# PLANNING AMENDMENT

| <b>SITE ADDRESS DETAILS</b><br>LAND OF FLEET ROAD, HOLBEACH<br>EASTING: 537267, NORTHING: 524903                                               |  |                                                                                                                                                                                 |  |
| <b>CURRENT APPLICATION NO:</b><br>This amendment cannot be considered unless the relevant reference is stated.                                 |  | H05 - 0446 - 22                                                                                                                                                                 |  |

| <b>FULL DESCRIPTION OF DEVELOPMENT OF CURRENT APPLICATION THAT THIS AMENDMENT RELATES TO</b>                                                                                             |  | RESIDENTIAL DEVELOPMENT - 55 DWELLINGS INCLUDING DEMOLITION OF EXISTING HOUSE - OUTLINE APPROVAL H05-1183-16 |  |

Drawing Title:  
BT7 - Floor Plans  
(S73 Planning Issue)

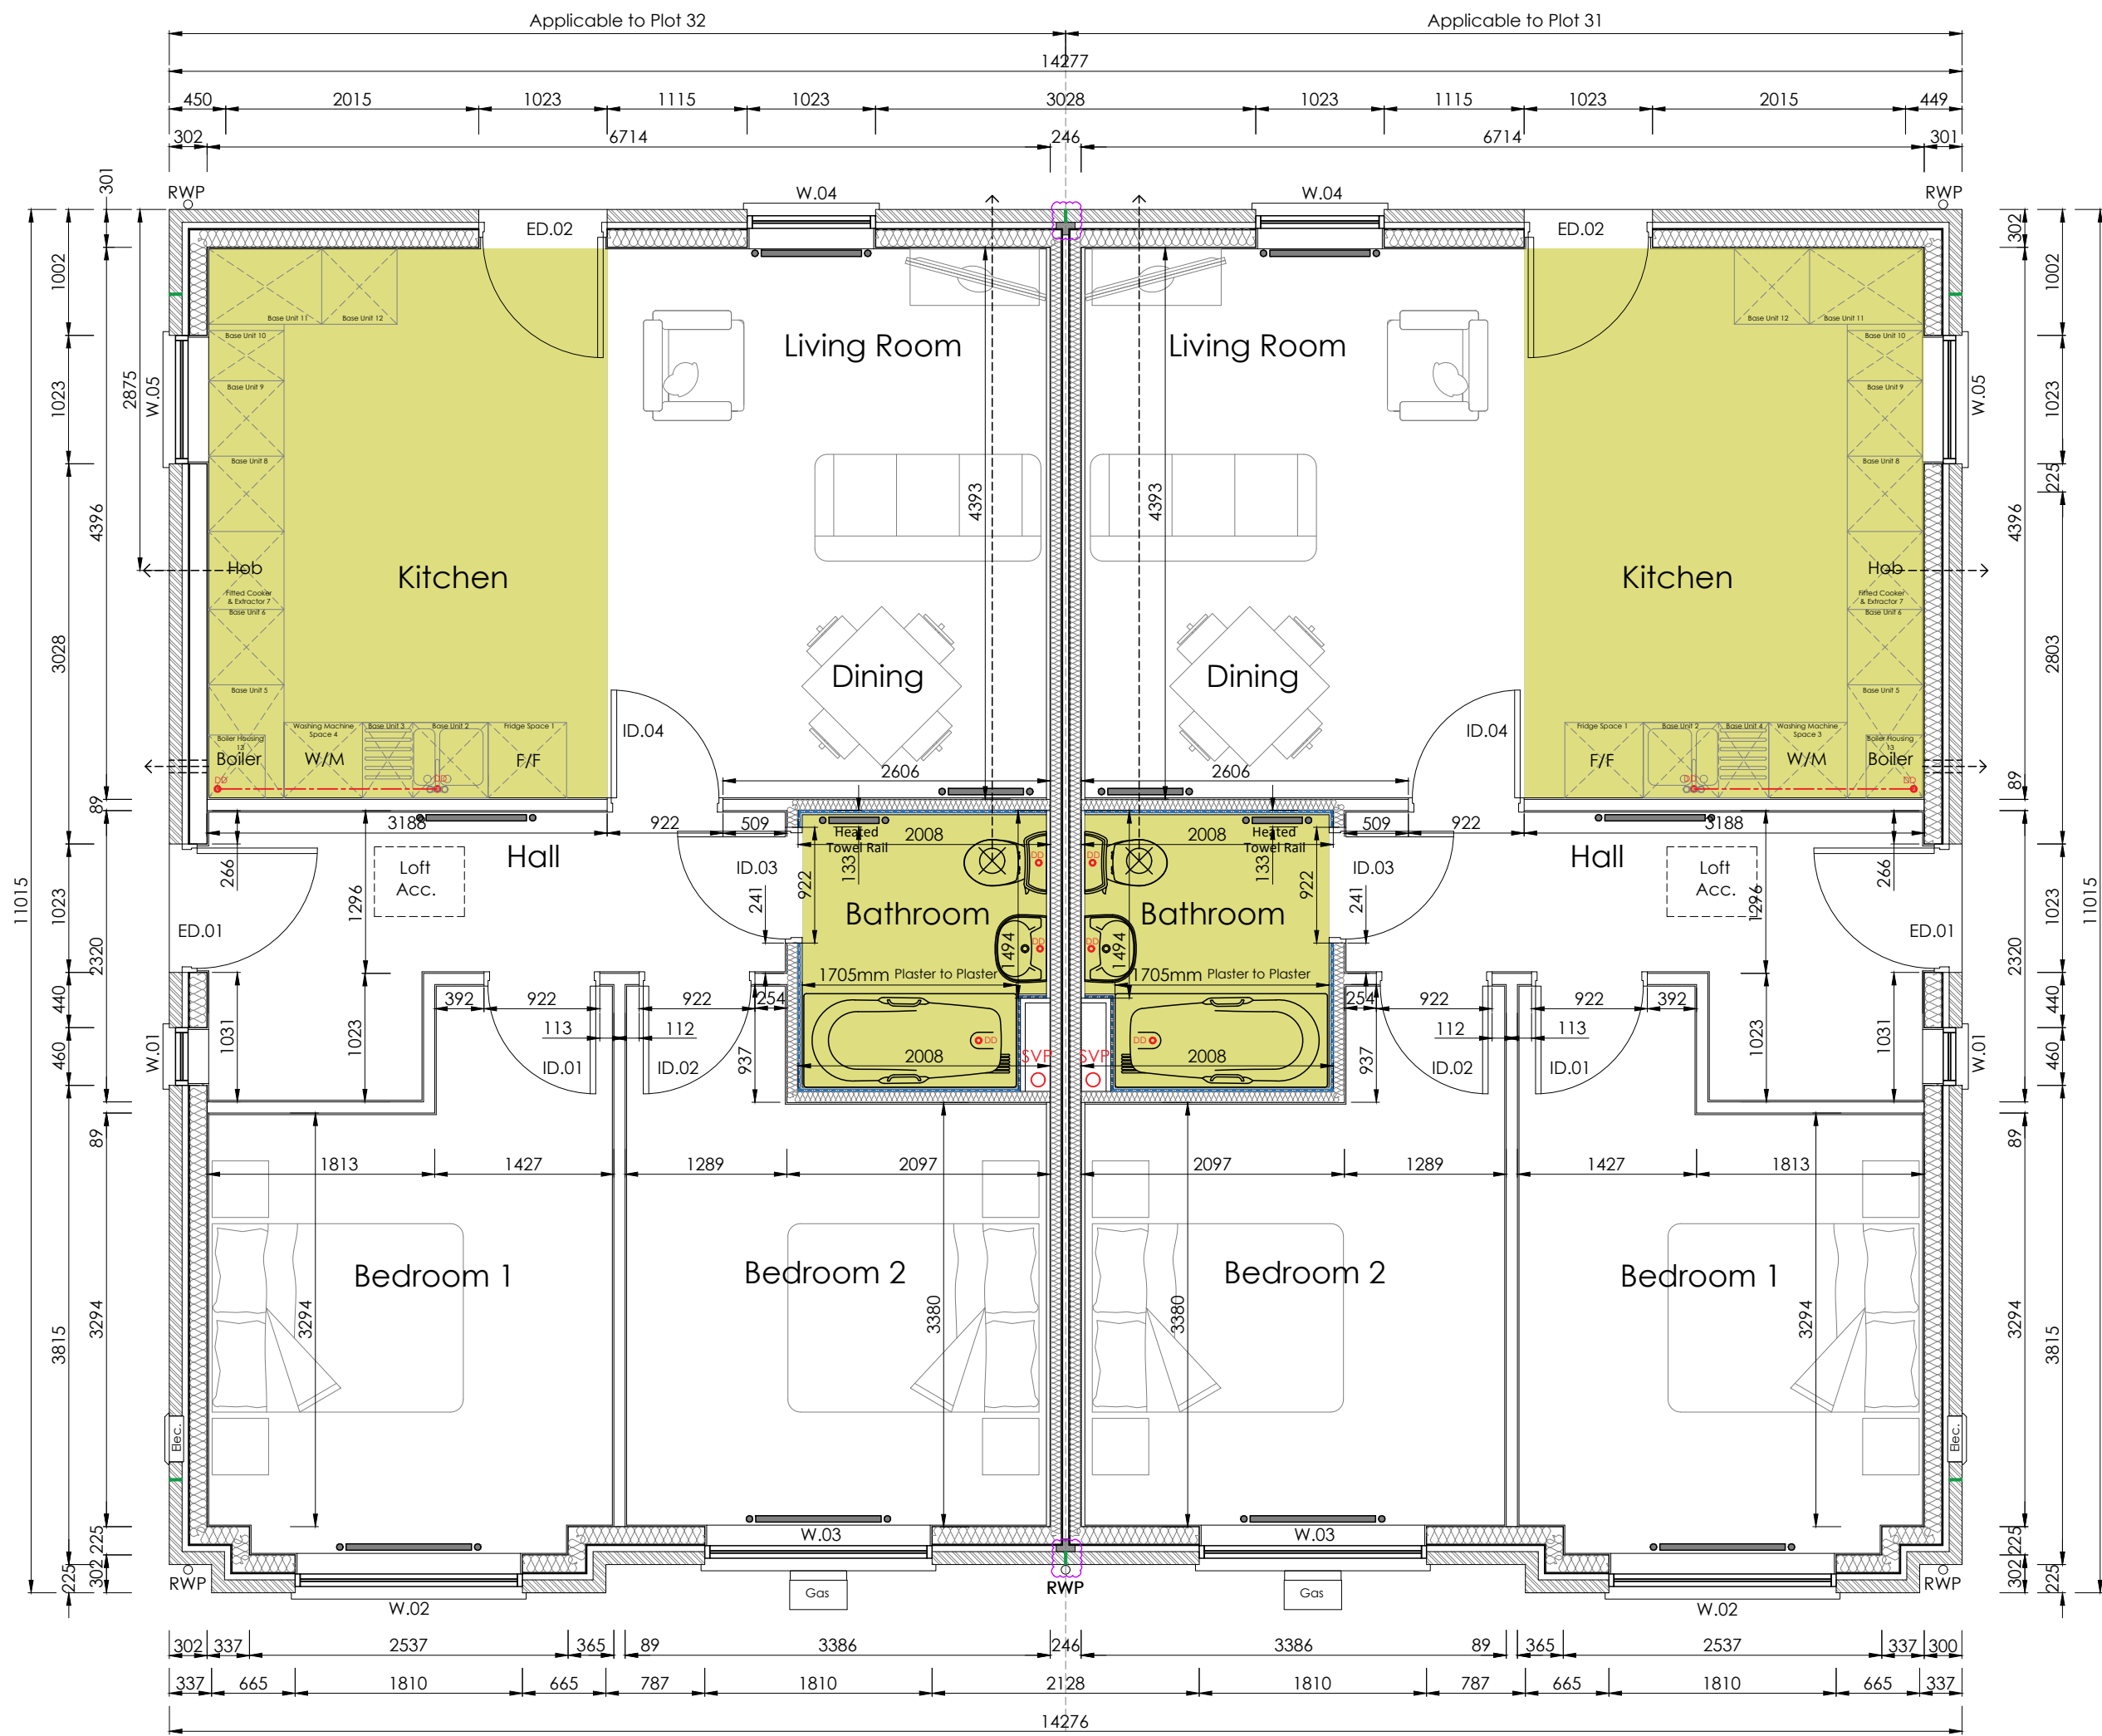
| State details of amendments proposed. (Give a full detailed list of the changes; and also mark these clearly on the accompanying plans. Only the changes listed here will be considered) |  | ROOF LIGHTS ADDED TO FRONT ELEVATION OF BT7 & BT8 TO ALLOW FOR MEANS OF ESCAPE FROM LOFT SPACE REFUGE.       |  |
